From: Fiona Fitzgerald <Fiona.Fitzgerald@arun.gov.uk>
Sent: 05 October 2021 11:46
To: Planning.Responses <Planning.Responses@arun.gov.uk>
Cc: David Easton <David.Easton@arun.gov.uk>
Subject: F/4/20/OUT

These comments follow submission of the revised Waste Infrastructure Statement (July 2021), odour assessment and noise impact addendum. Comments should be read in conjunction with previous Environmental Health comments.

Figure 2: Indicative extent of acoustic barrier at Ford Industrial Estate

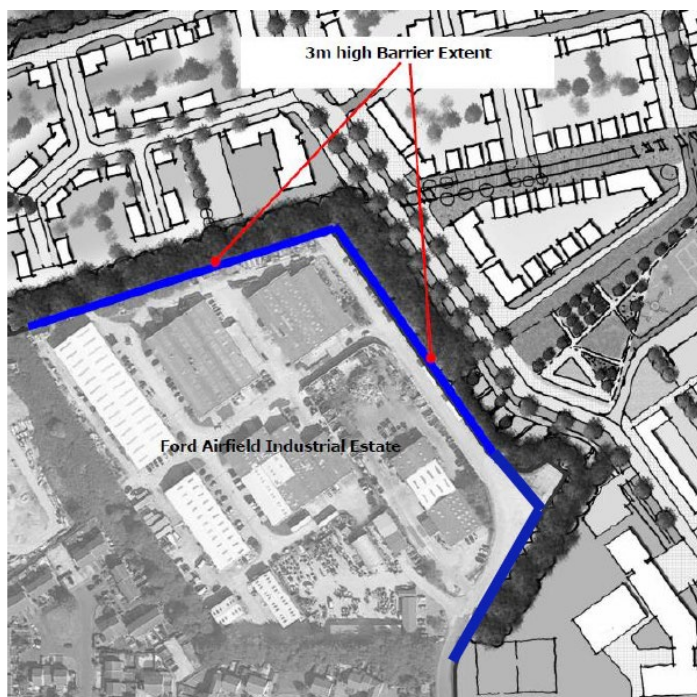
4.4 – This statement suggests that there may be gaps in the acoustic barrier to allow for pedestrian access. Please clarify if this is the case and if these gaps were taken into account during the noise assessment. Acoustic barriers must usually be complete without gaps if they are to be effective.

Figure 4: Typical illustrative plan showing noise mitigation principles, subject to detailed noise assessment and layout planning at reserved matters stage. Not for approval of detailed block layout or type/mix of housing.

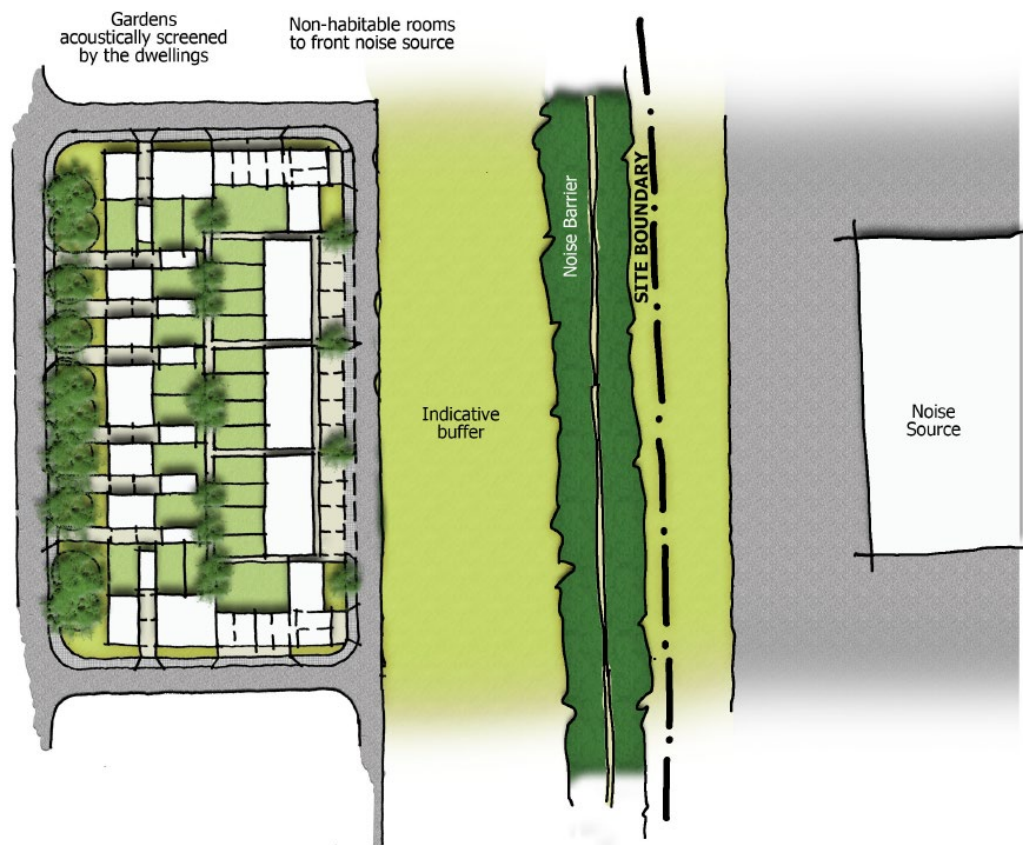
4.7 – see comments on 3.50 regarding where mitigation may be required.
